DECISION DELEGATED TO HEAD OF PLANNING

Application No: H09-0705-25 **Applicant:** A Sukerno
Proposal: Proposed Residential Development of 9 Dwellings
Location: Hooks Of Holbeach Land Adj. & Including 45 Fleet Street Holbeach
Terminal Date: 14th November 2025

PROPOSED SHADOWS

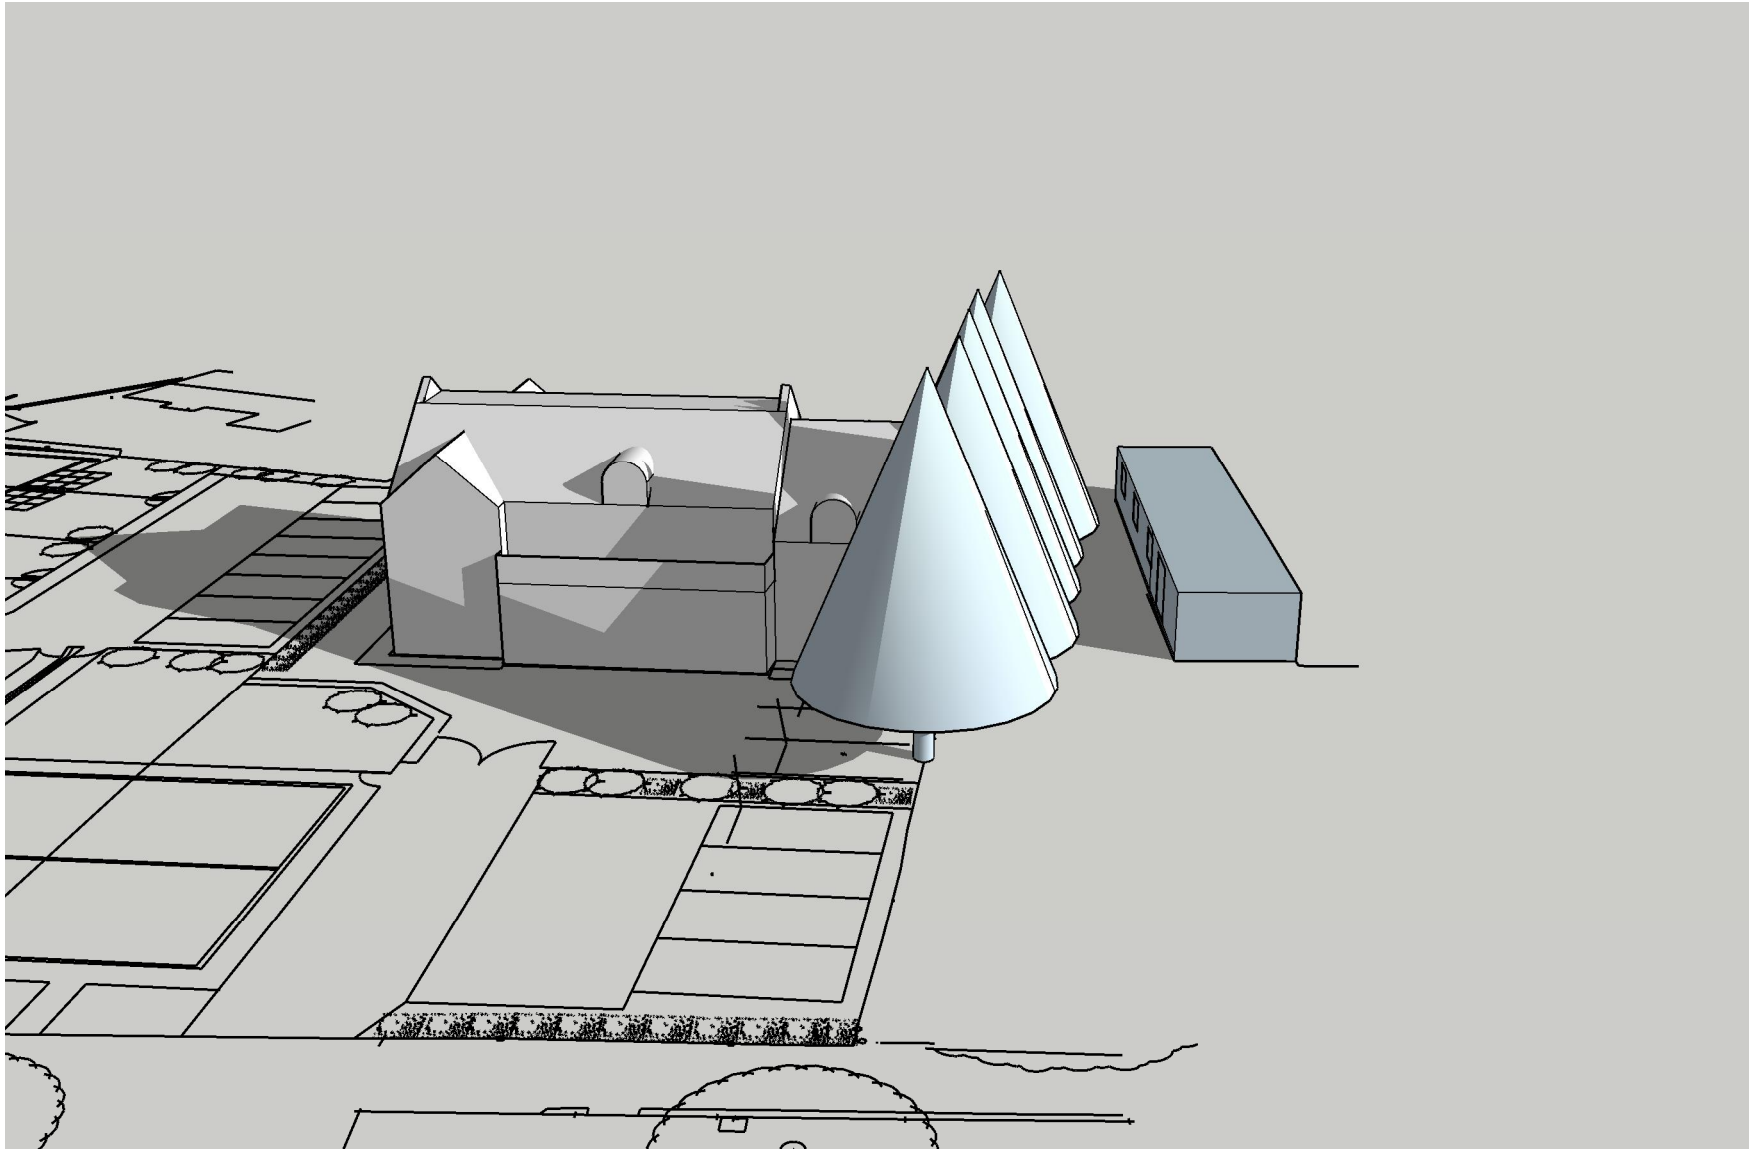
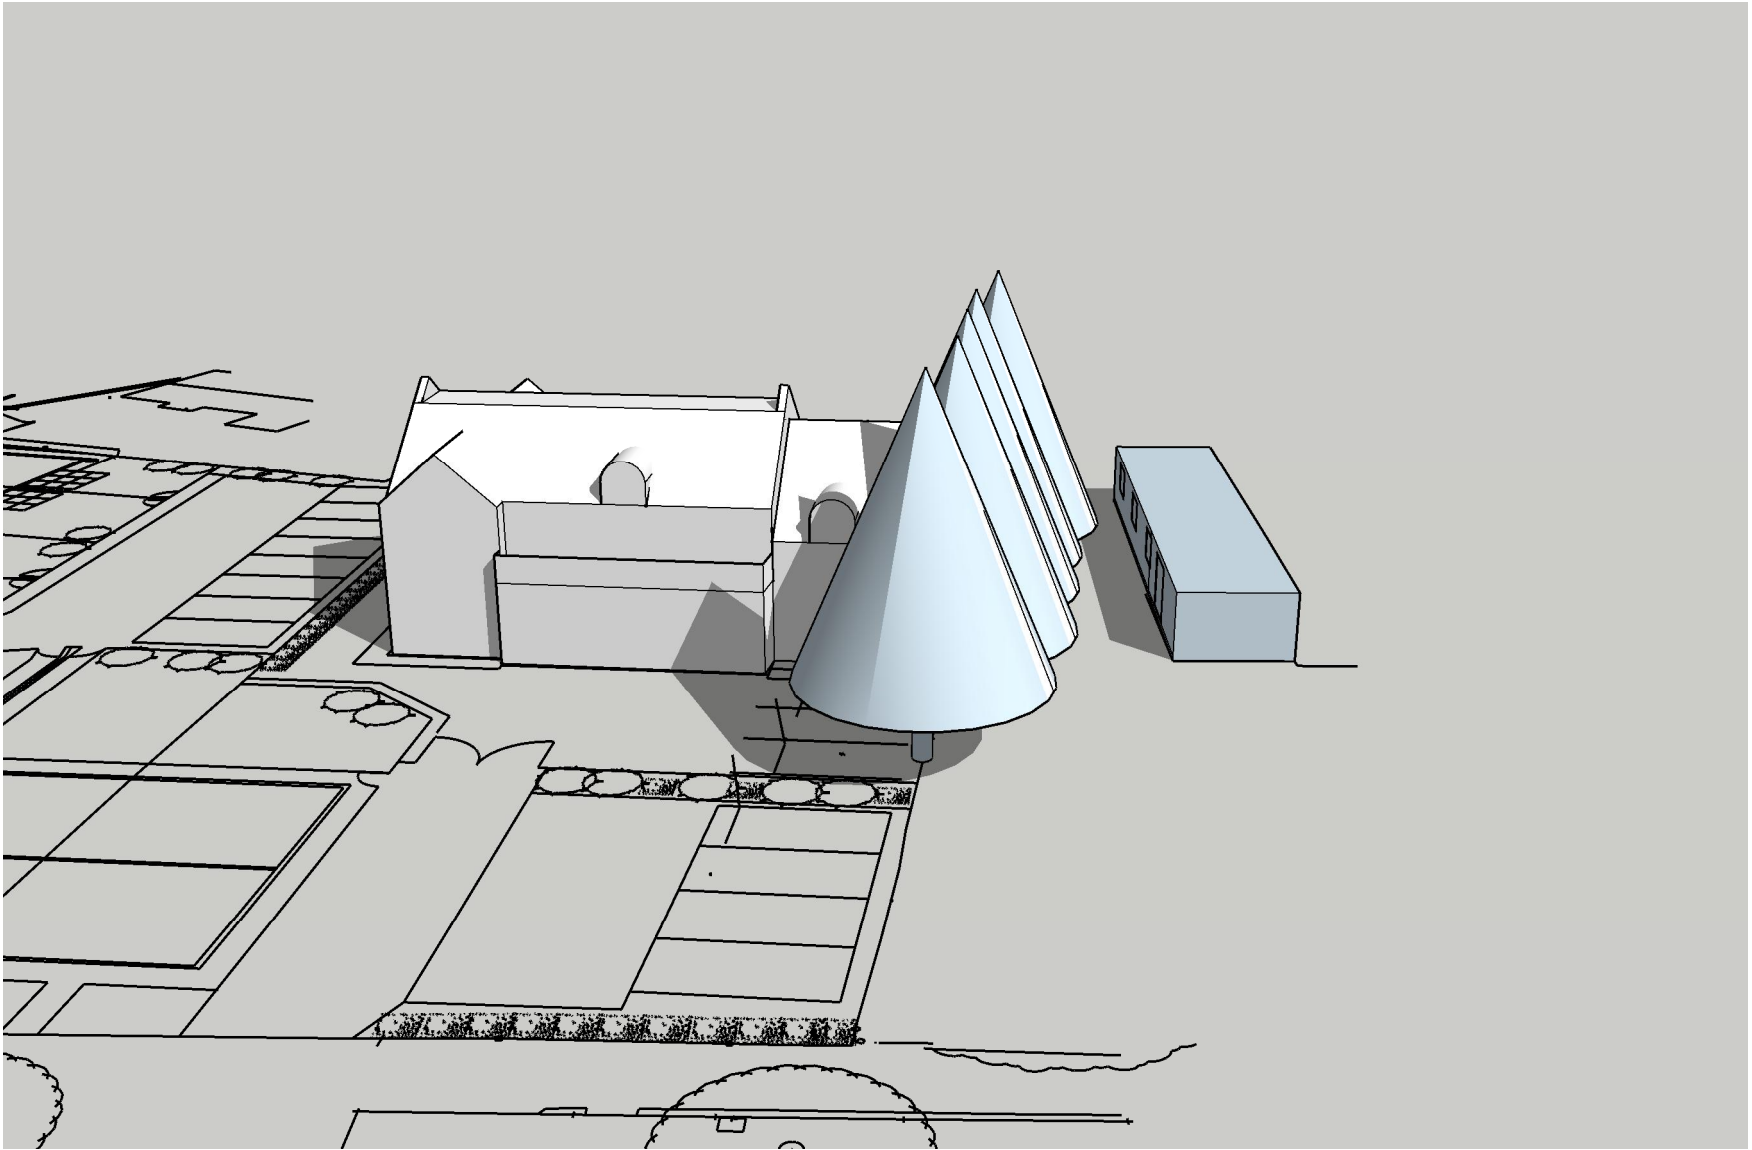
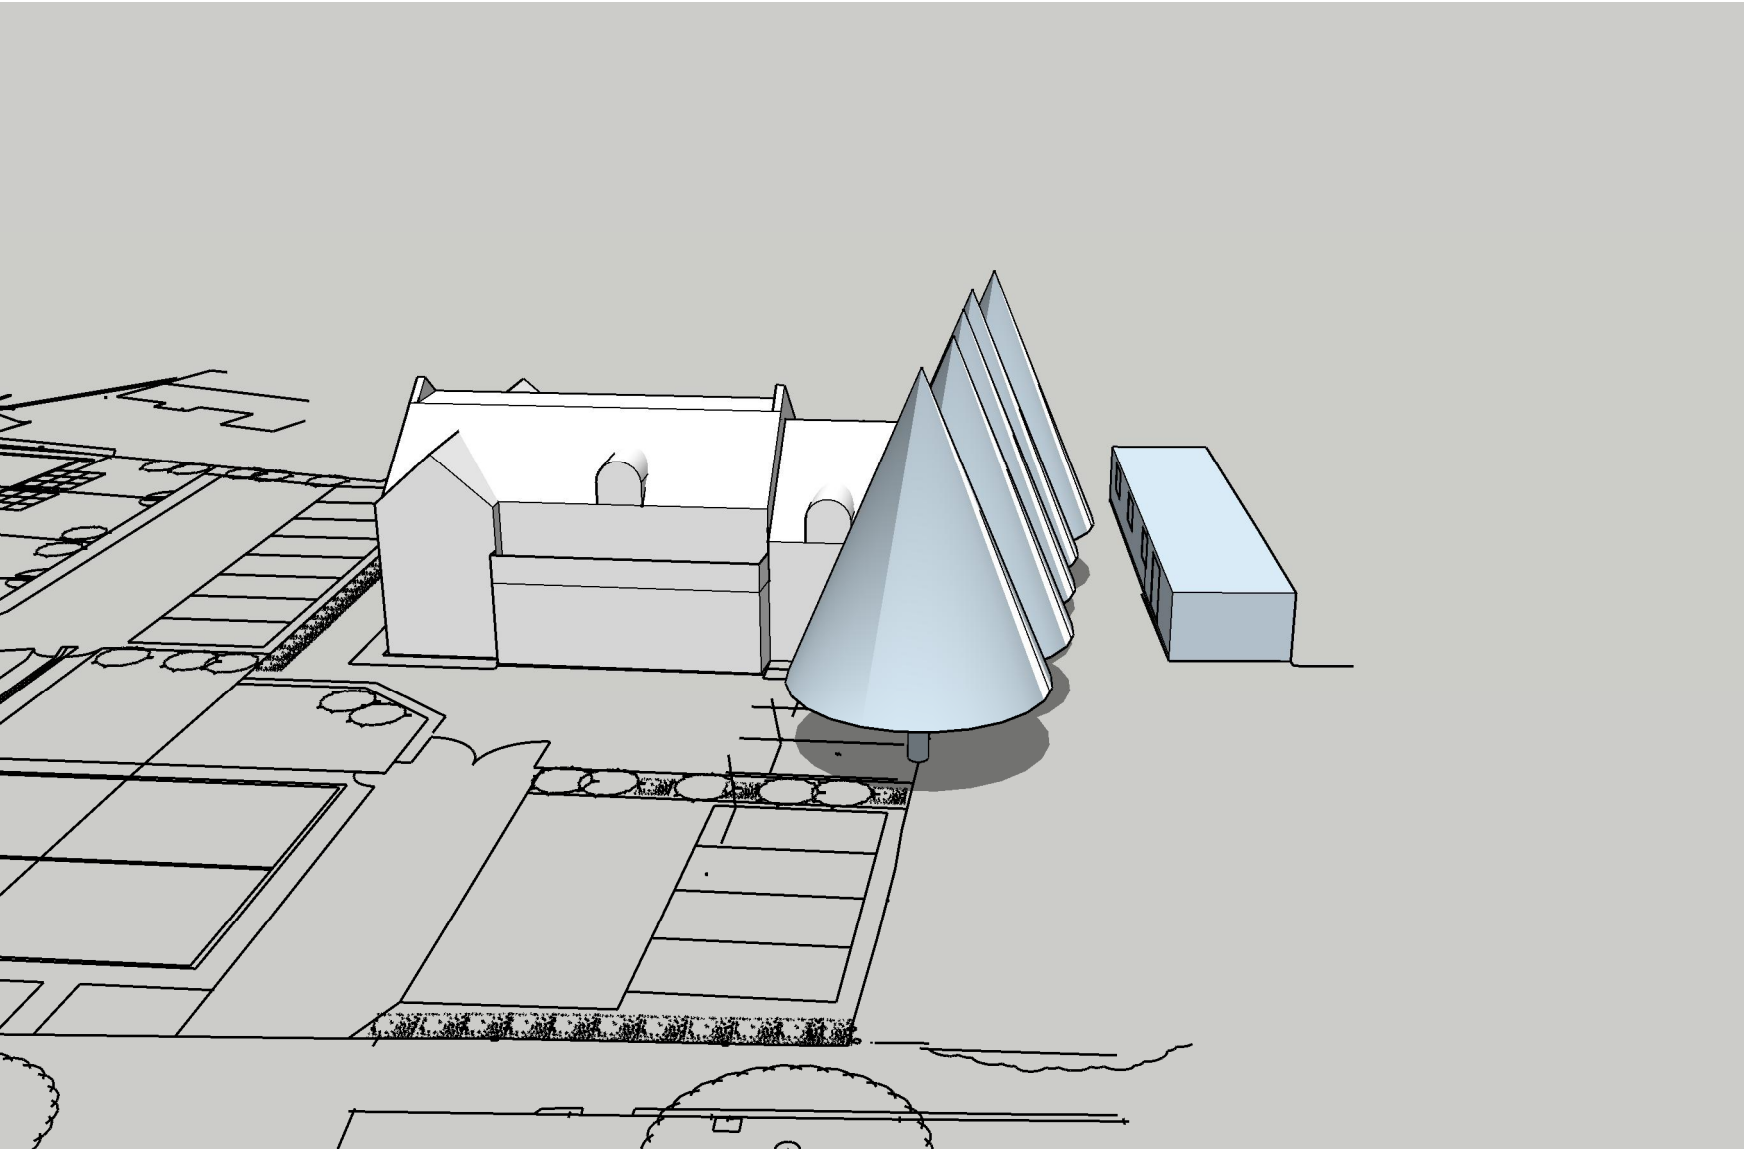
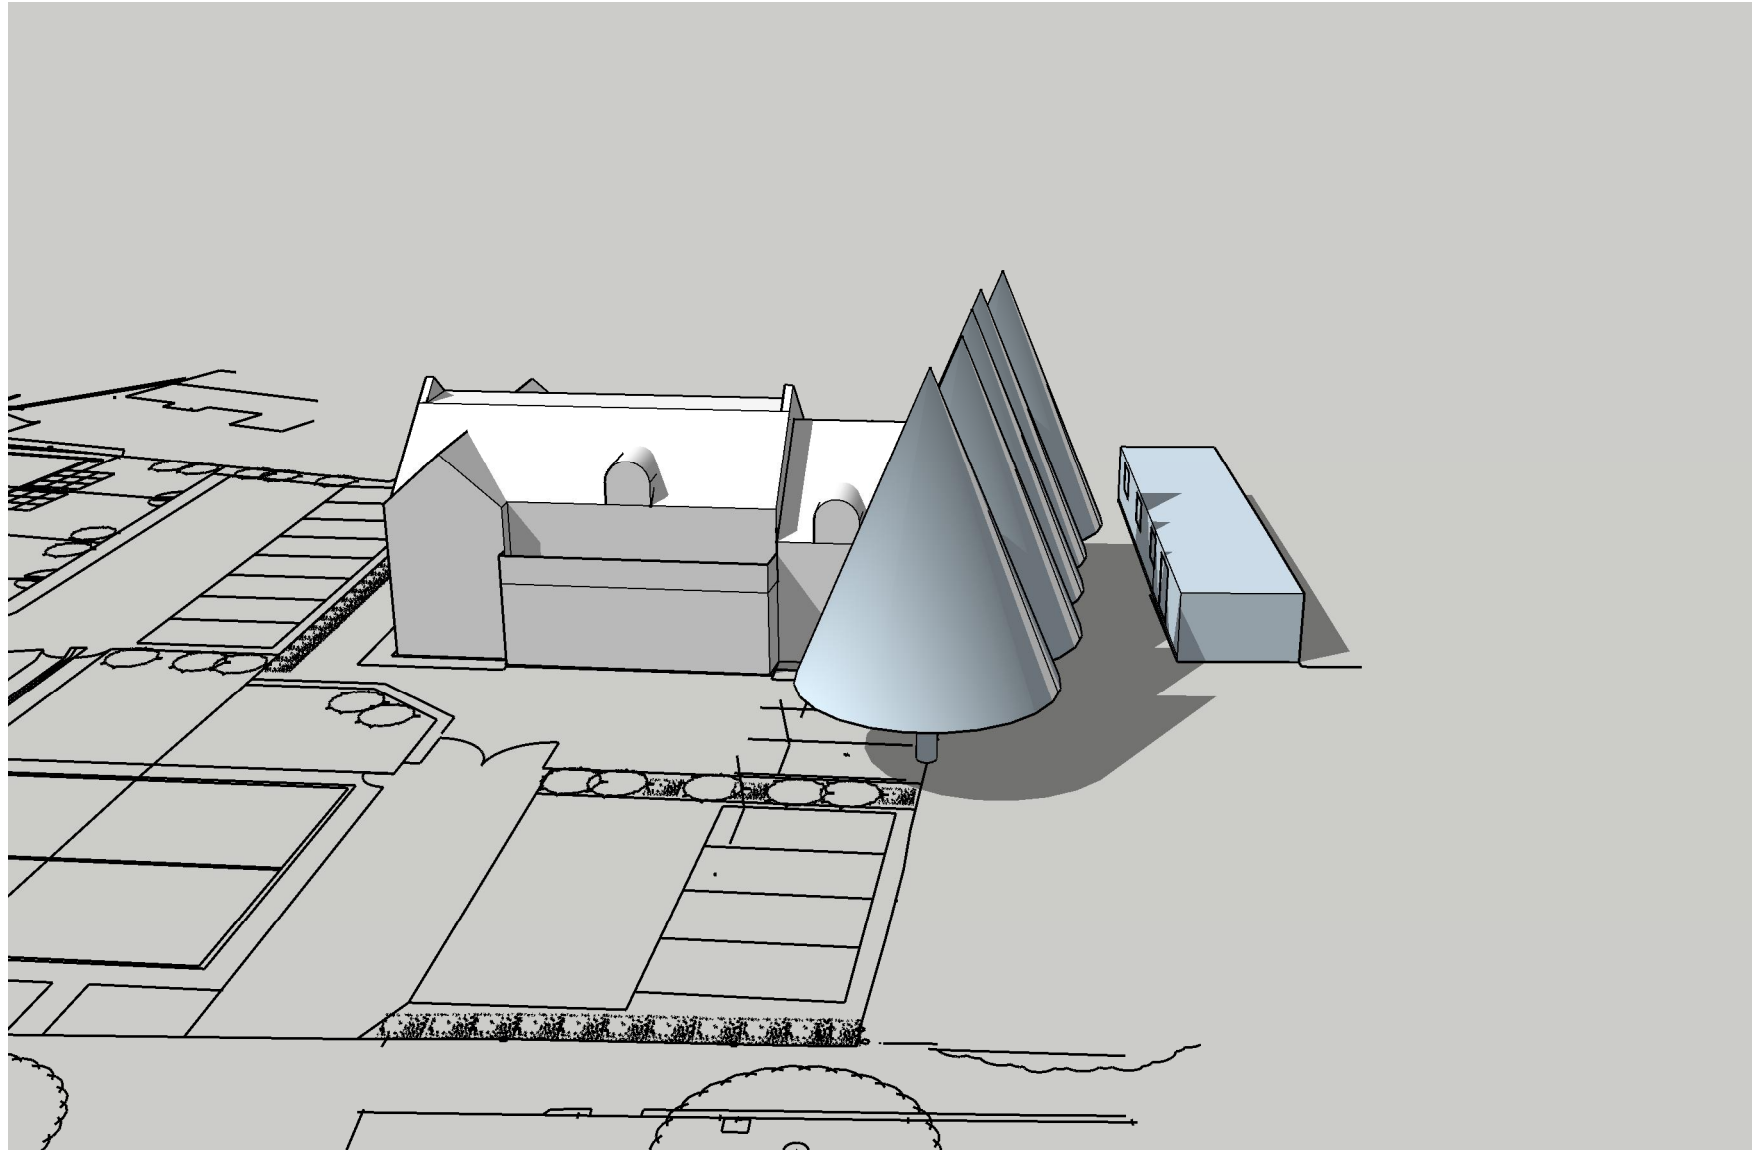
2. Amenity and Privacy The layout raises concerns about the amenity of future occupiers: The 6.8m separation between Plots 5/6 and Plot 4 is inadequate and would result in loss of privacy to Plot 4's garden. Plot 9's front balcony, although offset, would still allow direct views into Plot 8's rear amenity space, with only 10-11m separation between habitable rooms- below acceptable standards. The overshadowing assessment is limited, only considering one time of year and failing to assess impacts on all sides, particularly the garden east of Plot 9.

A daylight assessment has been provided as part of this proposal. This shows that the western elevation of the adjacent care home is already in shadow due to the existing trees. The proposal would not exacerbate the level of shadow cast. In stepping the roof towards this boundary downwards, there would be a reduced level of shadow cast in any event. The rear windows of Plot 9 would create some level of overlooking towards 1 Creewood Close, albeit this is not considered to be overly untoward.
